From: Sue Howell <Sue.Howell@arun.gov.uk>
Sent: 30 September 2021 13:43
To: Planning.Responses <Planning.Responses@arun.gov.uk>
Cc: Anita Gardner <Anita.Gardner@arun.gov.uk>
Subject: RE: Planning Consultation on: LU/218/21/PL

Response to Planning Application

Application ref: LU/218/21/PL

Description: Erection of a semi-detached building comprising 2 No x 2 bedroom houses with associated parking and landscaping works (resubmission following LU/58/21/PL). This site may affect the setting of a listed building & is in CIL Zone 2 and is CIL Liable as new dwellings.

Site Plan as Proposed

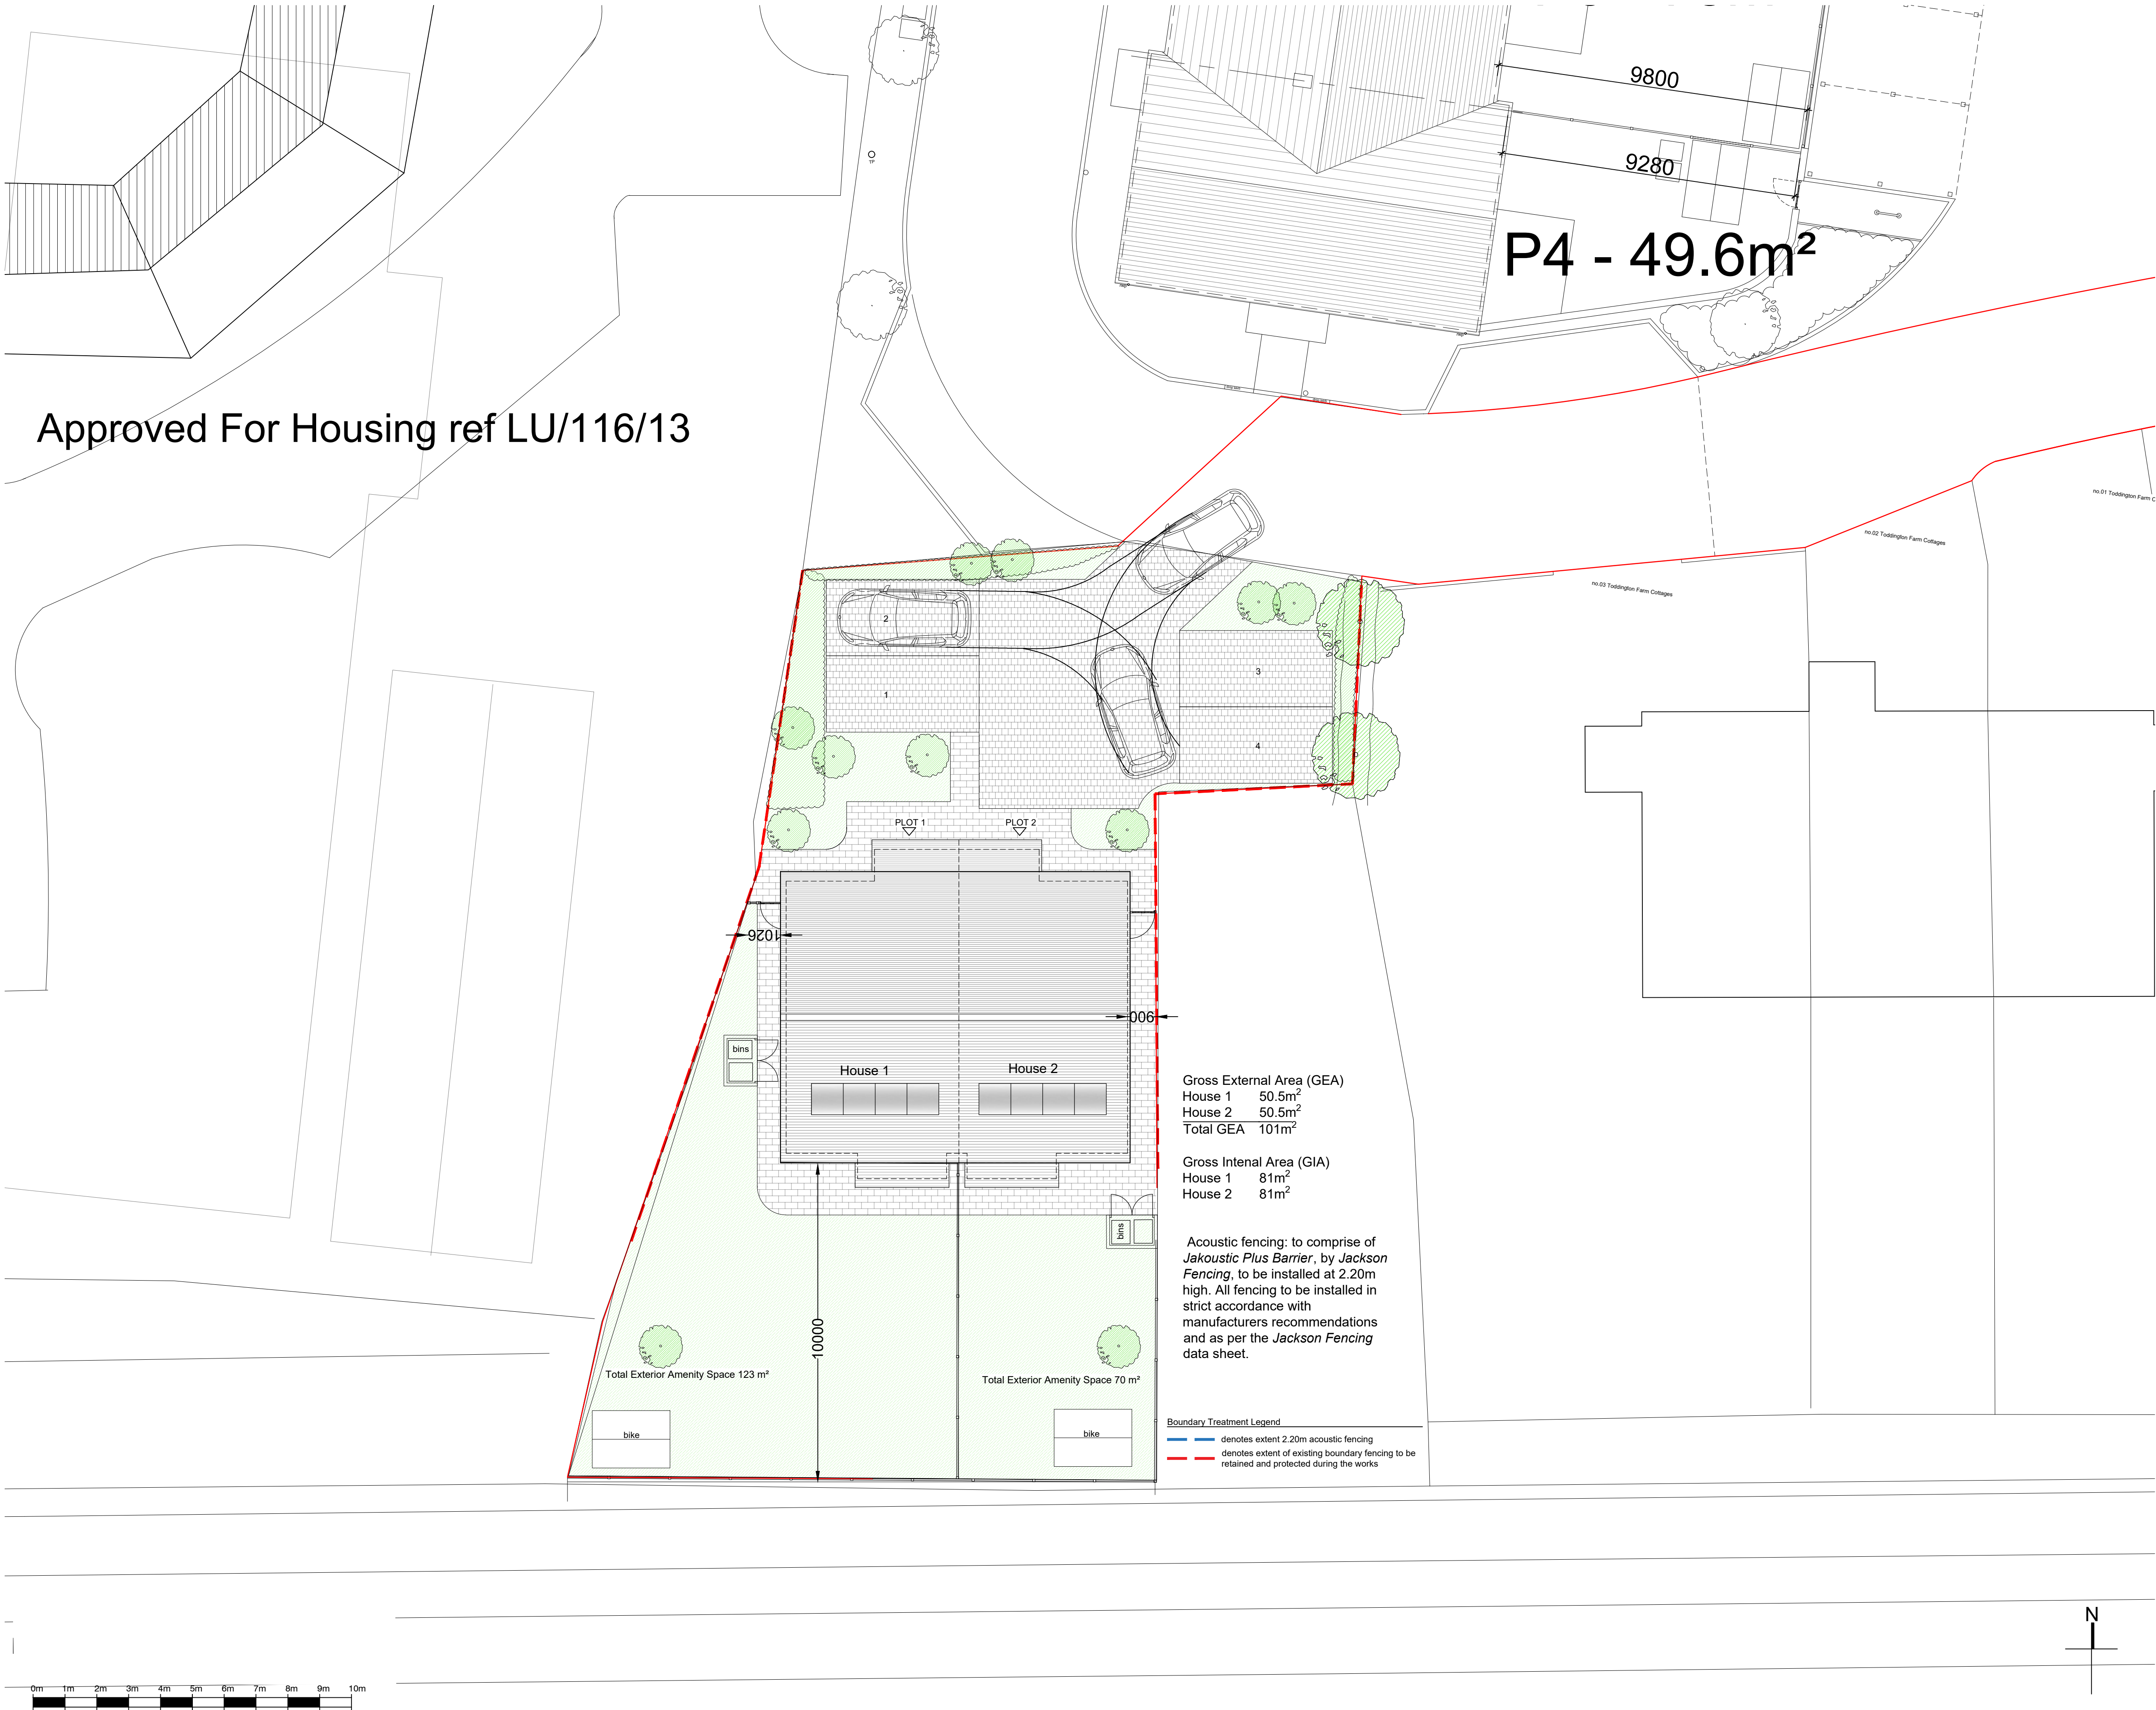
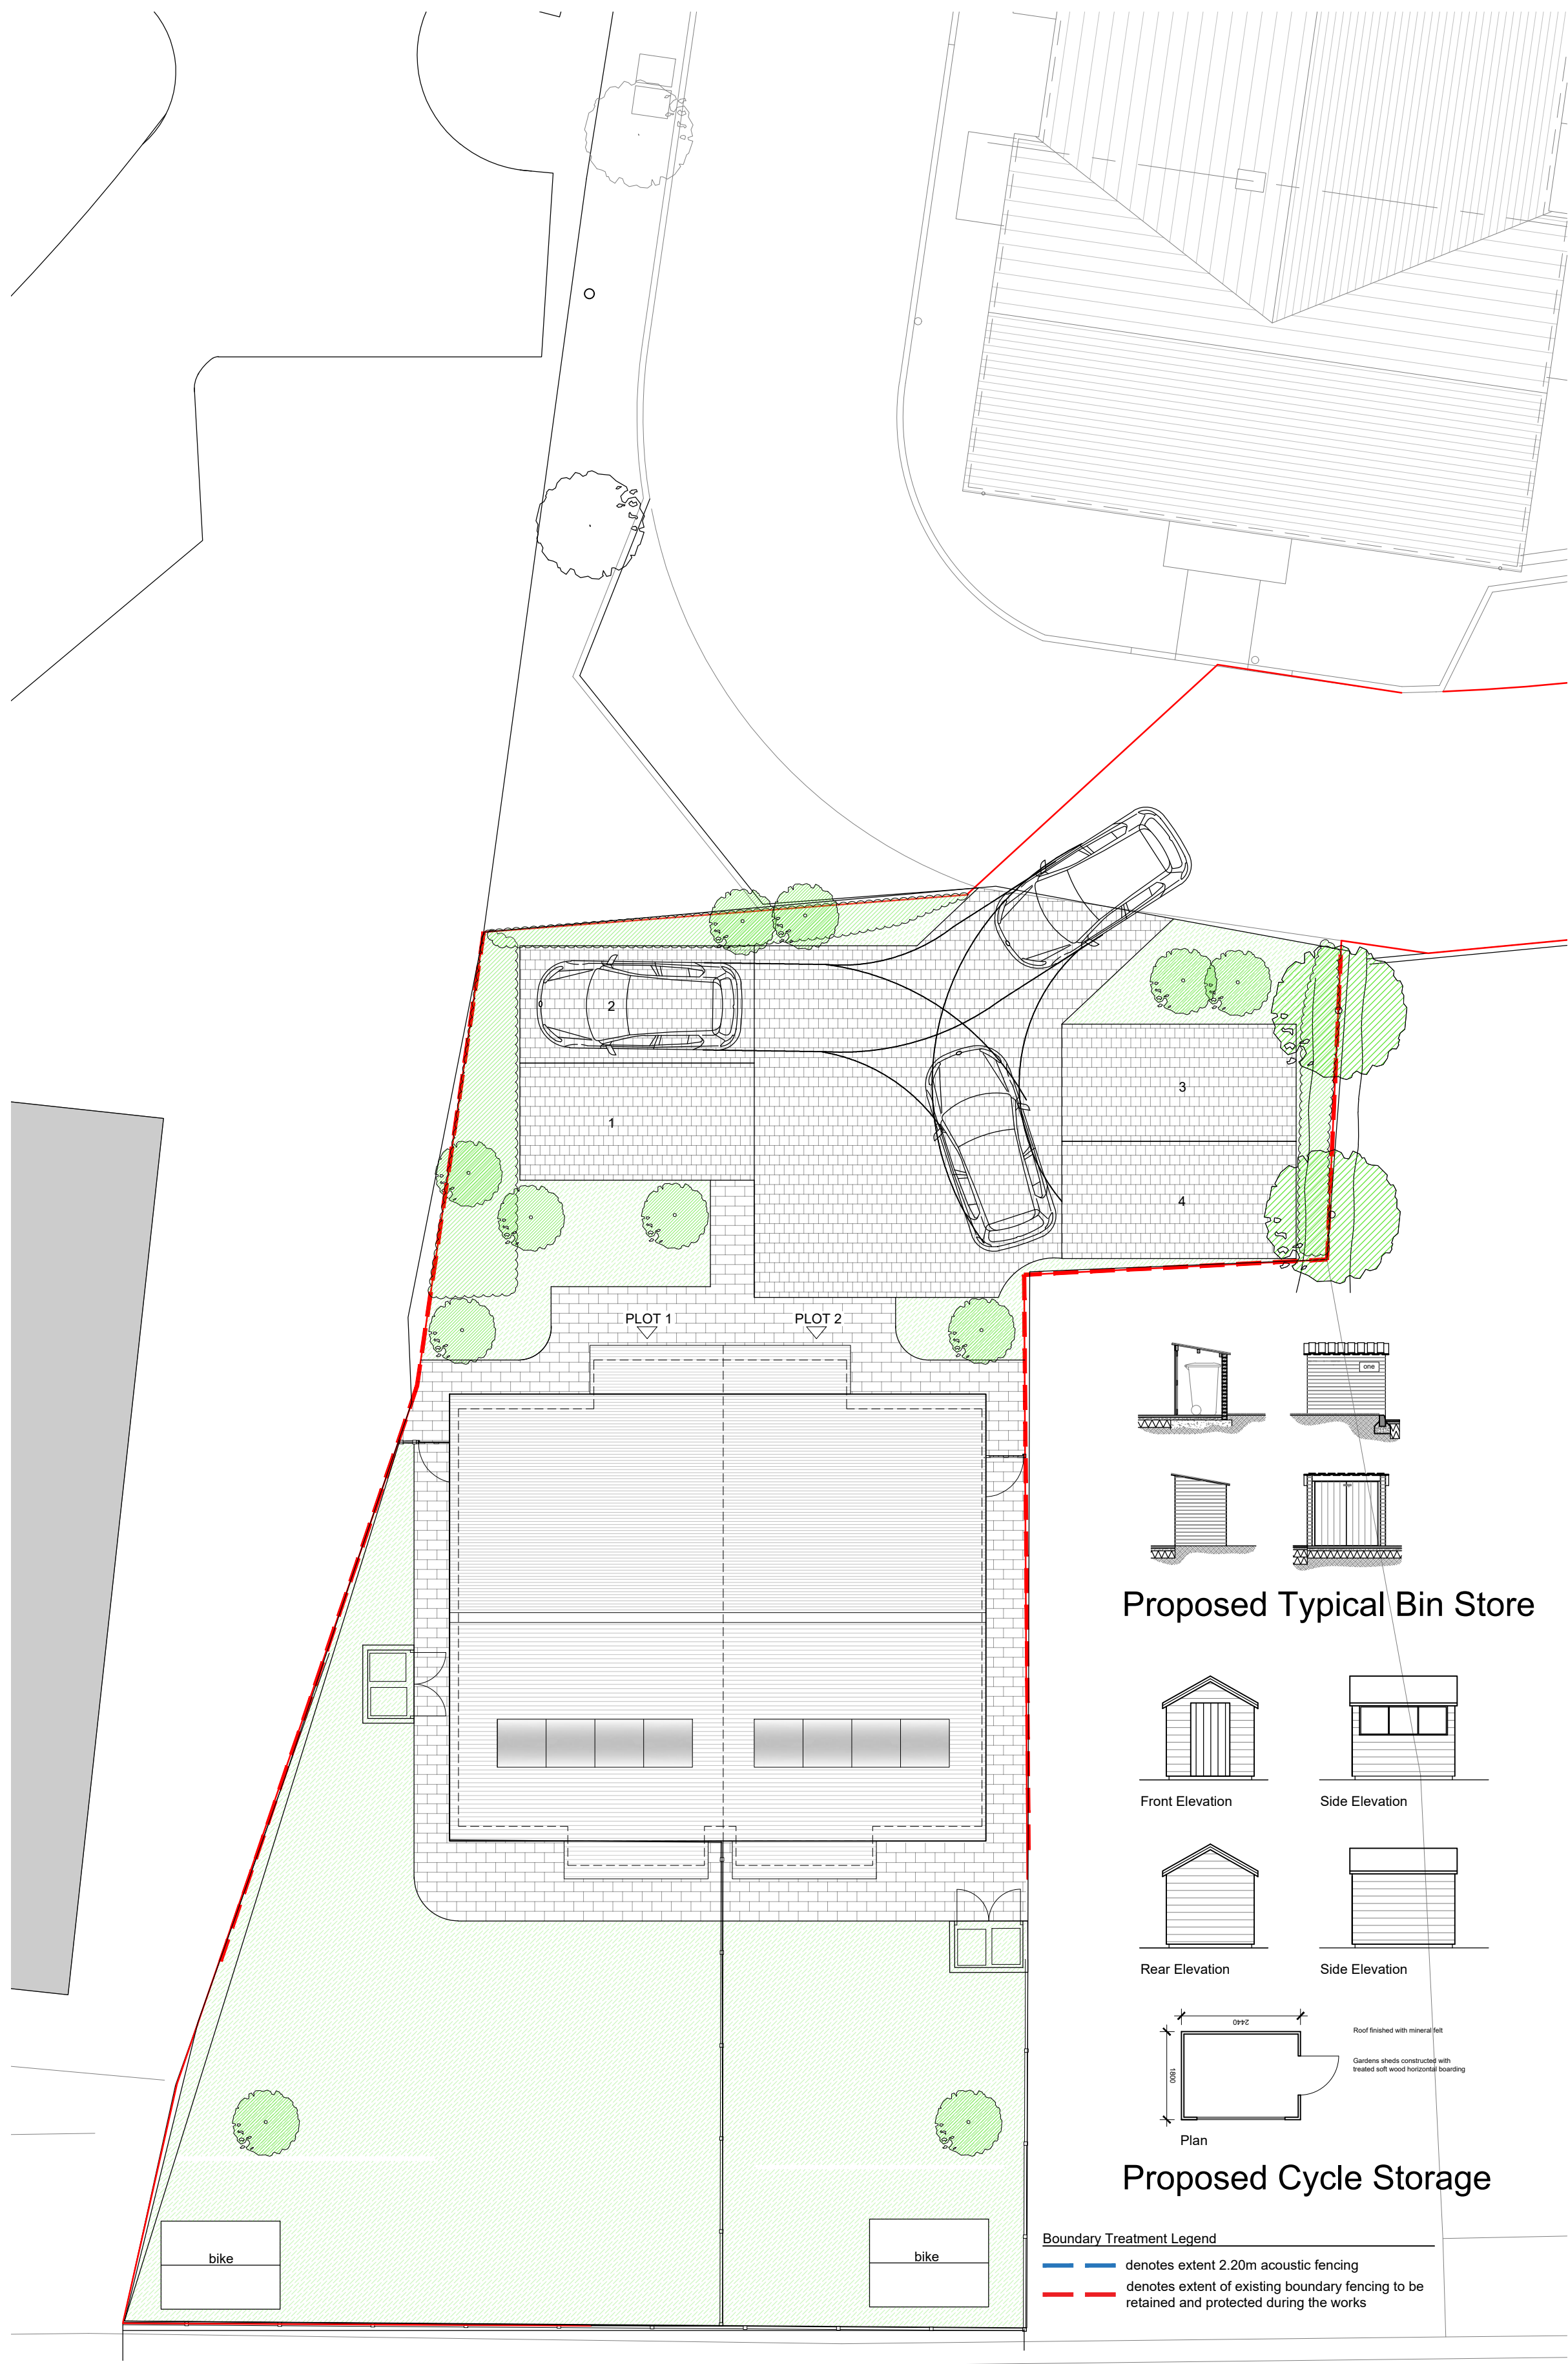
The NPPF para 124/127 relate to good design principles which equally apply to small infill and replacement development. The indicative site layouts has made reference to indicative planting along the frontages of these new dwellings. These details would require expanding in the form of a detailed planting plan and specification detailing species choice, actual plant quantities, planting densities and size at time of planting.

These dwellings would fit within the scheme of new dwellings in this location. The rear garden of these proposed dwellings adjoin a boundary with an existing railway line. Planting will need to be considered within the boundaries to screen along the boundary and the shown 2.2m acoustic fence.

Garden sizes needs to meet the requirements of Aruns Design Guide SPD Jan 2021

Landscape provision to the dwellings will need to be confirmed along with the recommendation to provide screen buffer planting to the rear gardens. All proposed planting should be considered and its connection for biodiversity and habitat explored, with a biodiversity net gain following development. Trees specified should be at a size which allow instant impact, but which will establish and mature as the site develops.
